Planning Services Sign Permit Review Form

Date of Submittal	Application Number	Applicant	Landowner
03/22/19	SIGN1903-0003	Michael Presnell	A + D Service Center, LLC
Contact Person	Contact Number	Sign Location	PIN Number
Michael Presnell	919-210-1855	5077 NC 87 N.	9569-72-0550.000

ELEVATION VIEW
WOOD POLE SIGN
SCALE: 1/4" = 1'-0"

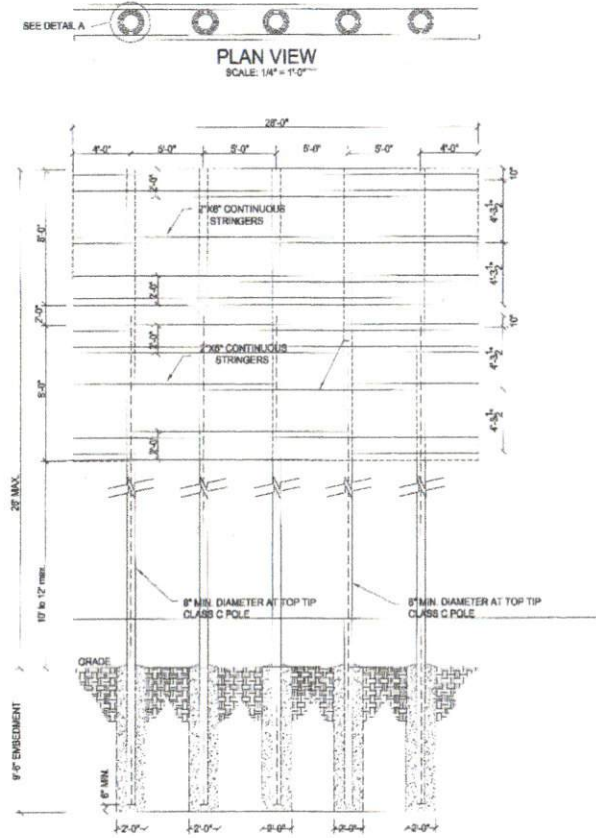
- OAS reconstruction allowed under guidelines of NCGS 136-131.2
Modernization of outdoor advertising devices
- "Site plan" submitted w/ app proposes sign in diff location - must be put back in same location
* resubmit site plan with accurate location
- Approved by ~~NCDOT~~ for a 28' x 18', max height of 30'
- cannot be increased
